December 23, 2014
06267

Application for Level 1 Site Alteration
Proposed Parking Lot Expansion

We have reviewed the staff comments emailed on December 11, 2014 and offer the below responses:

OVERALL SITE PLAN
SCALE= 1"=20'

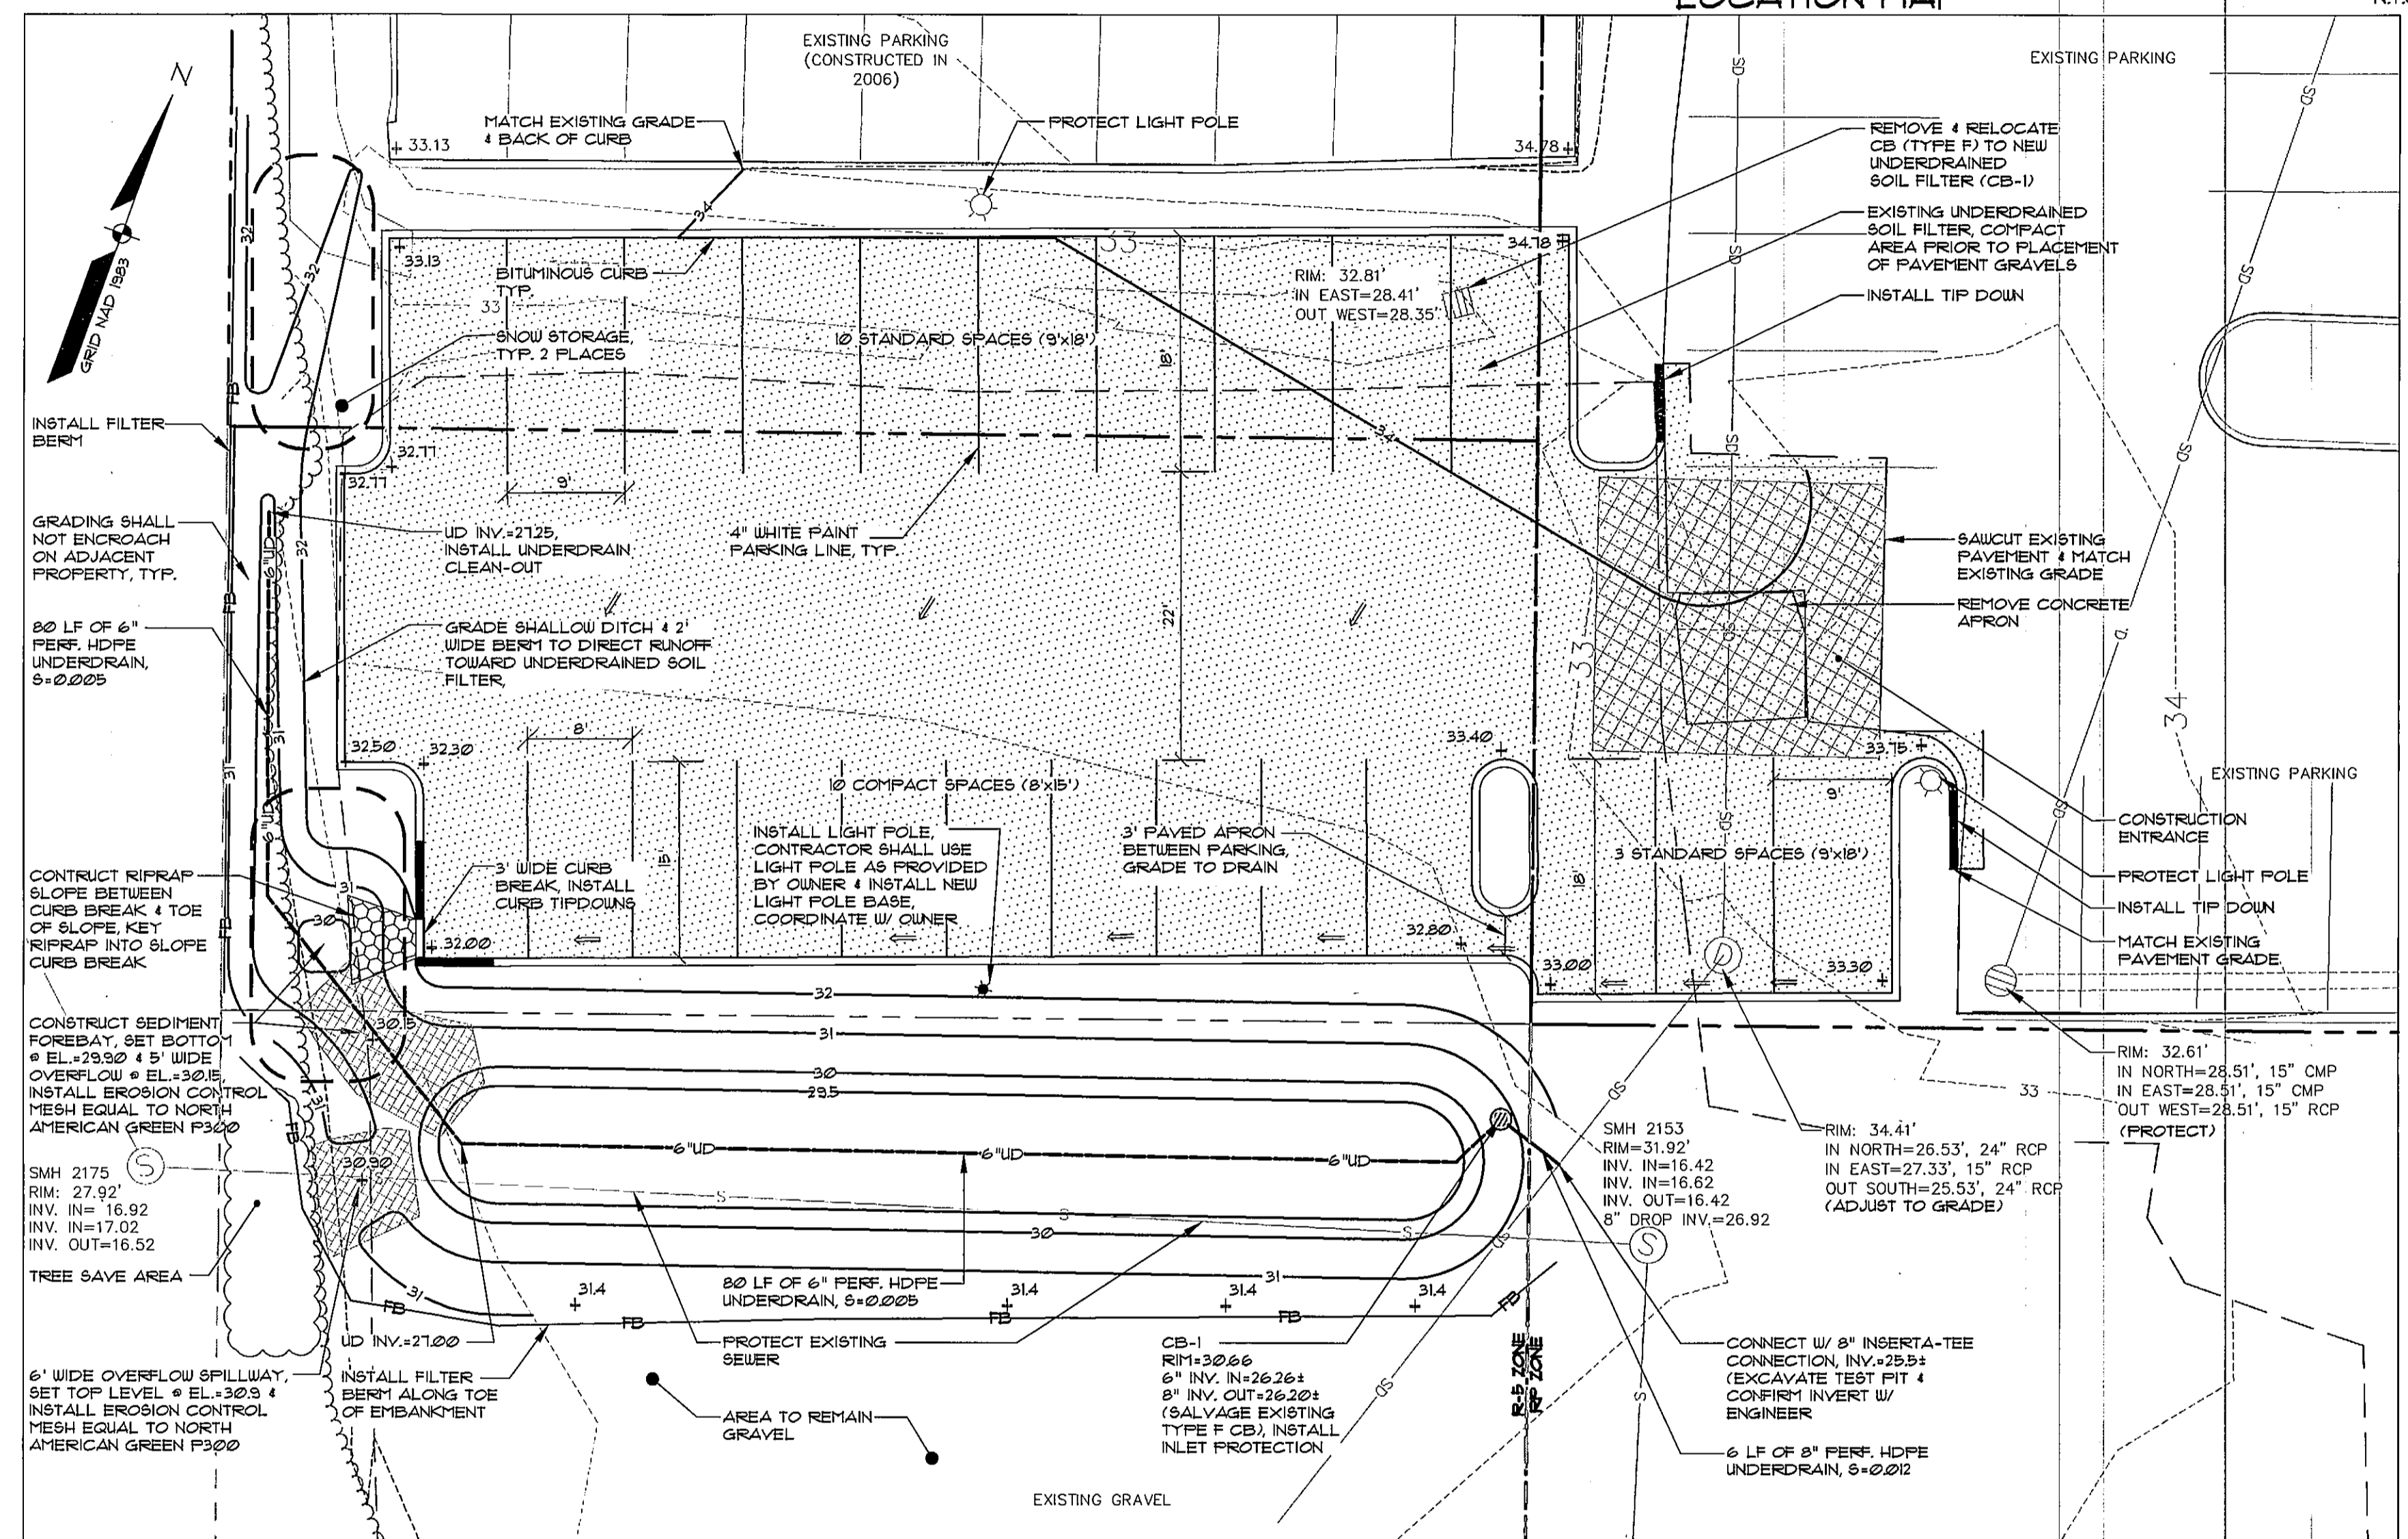
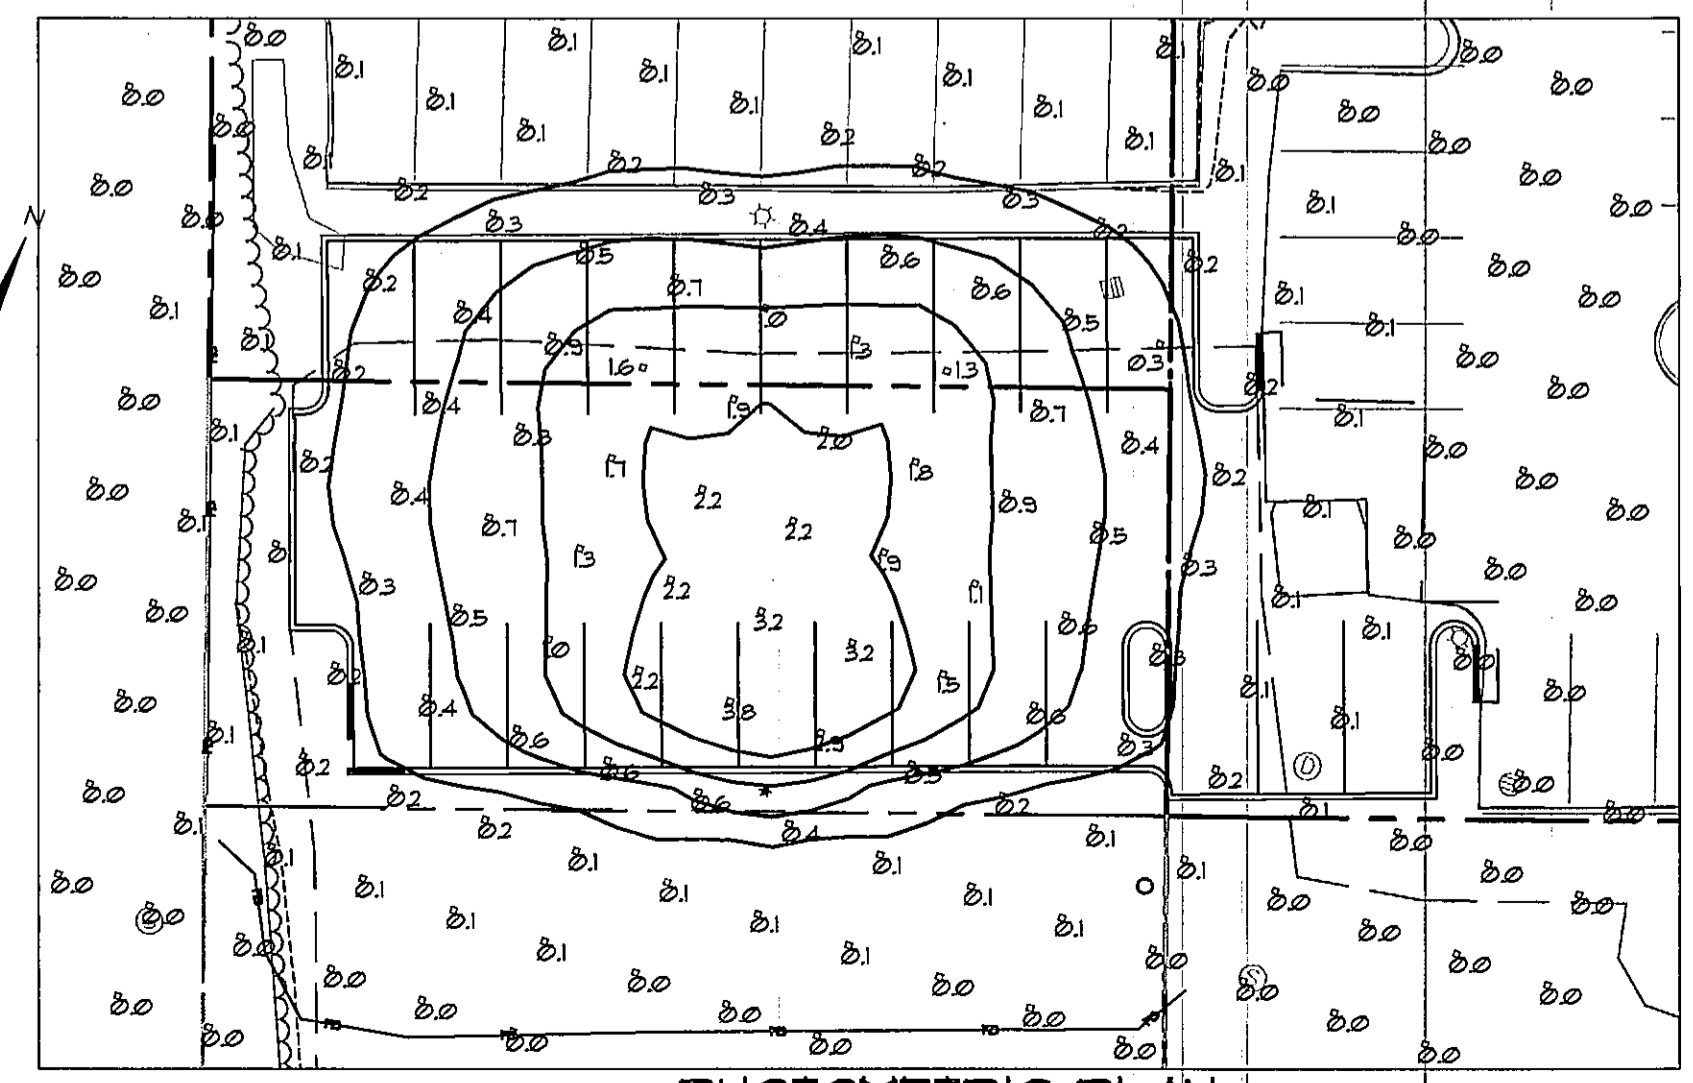
1. Signed and stamped boundary surveys are enclosed for your review.
2. Sheet 2 was revised to show an 8" invert out for the catch basin serving as the primary outlet of the proposed underdrained soil filter. The 8" pipe will extend approximately 6 feet and connect to an existing 24" RCP via an insert-a-tee connection. We respectfully request a waiver from the standard requiring a new manhole at this location.

- 1a. Sheet 2 was revised to show a temporary sedimentation barrier (filter berm, designated FB) immediately downgradient of the embankment. Erosion control notes and details on Sheet 3 provide additional requirements for site stabilization, include specific requires for the installation of sedimentation barriers prior to the beginning of construction.
- 1b. OK.
- 1c. A stormwater runoff analysis was developed using "HydroCAD" computer modeling software, which incorporates the TR-55 and TR-20 methodologies as provided by the Soil Conservation Service of the U.S. Department of Agriculture. A Class 'D' Medium Intensity Soil Survey published by the United States Department of Agriculture, Natural Resources Conservation Service for

**UNDERDRAINED SOIL FILTER INSPECTION & MAINTENANCE**

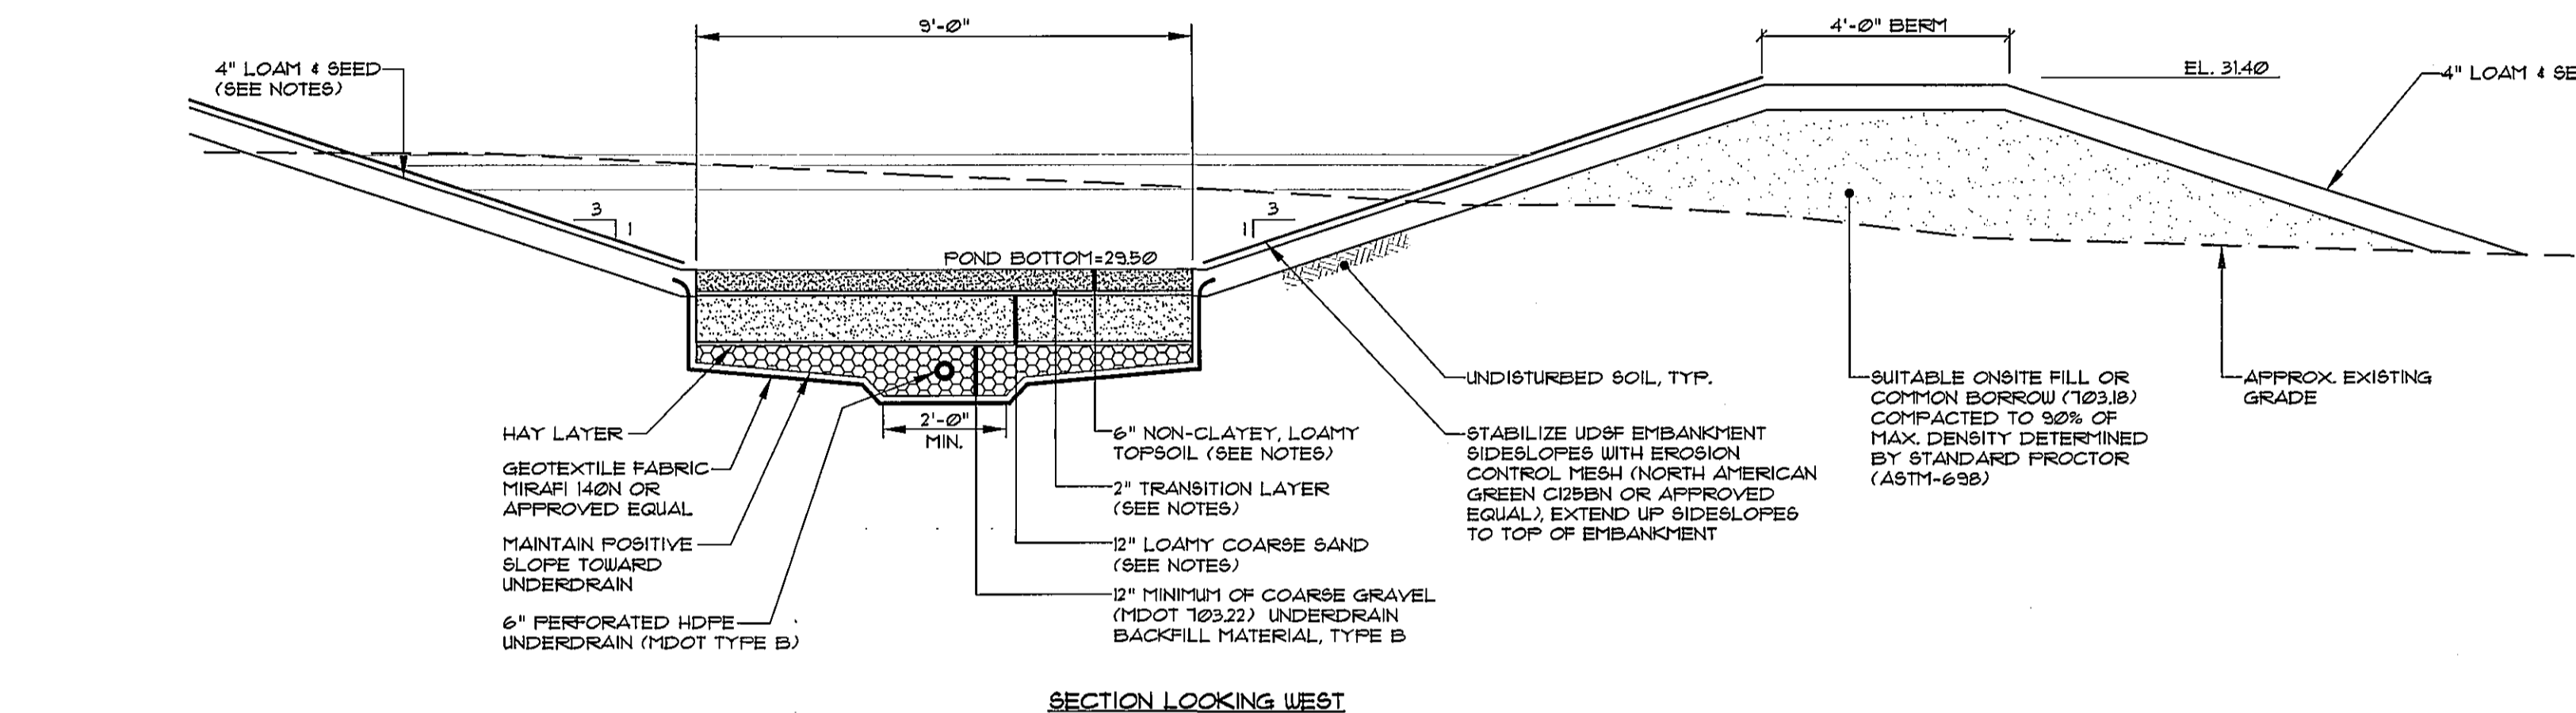
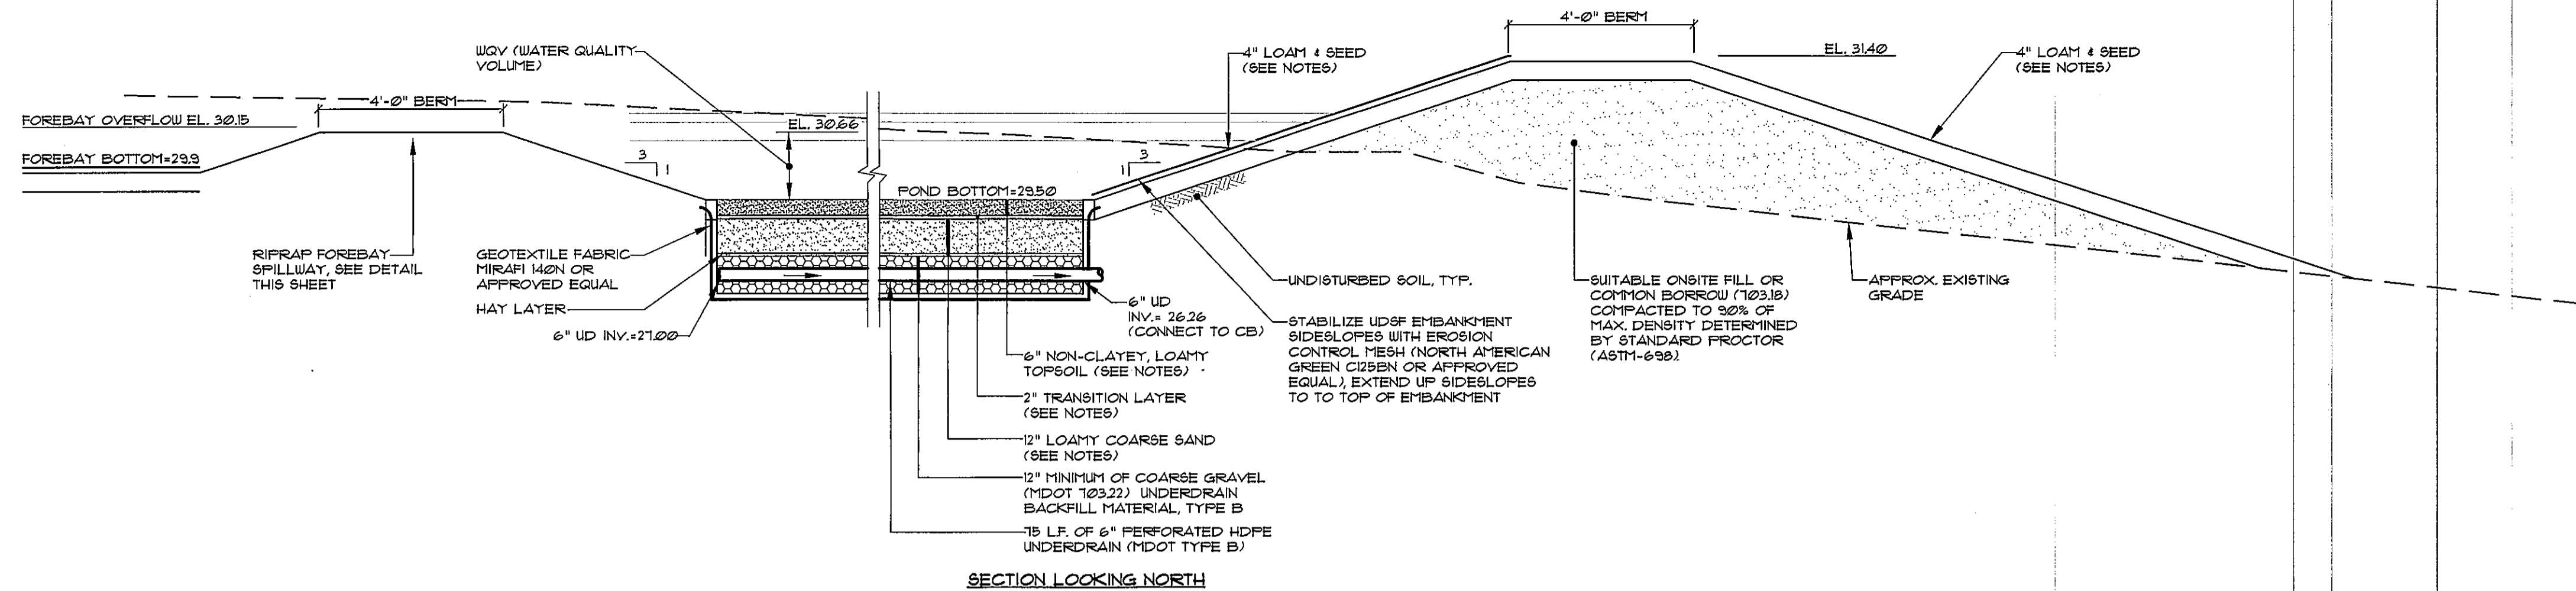
2. We have initiated correspondence with the Department of Public Services and Portland Water District with regard to the existing sewer pipe. Existing easements will be added to the plan if found applicable.
3. The proposed overflow spillway is set at elevation 30.9, and the top of embankment was revised to be 31.4 so that sufficient freeboard is provided. Please note that the HydroCAD model predicts that water elevations will not overtop the overflow spillway during the 2-, 10- and 25-year storm events.
4. Sheet 4 was revised to show Eyecare Medical Group as responsible for maintenance.
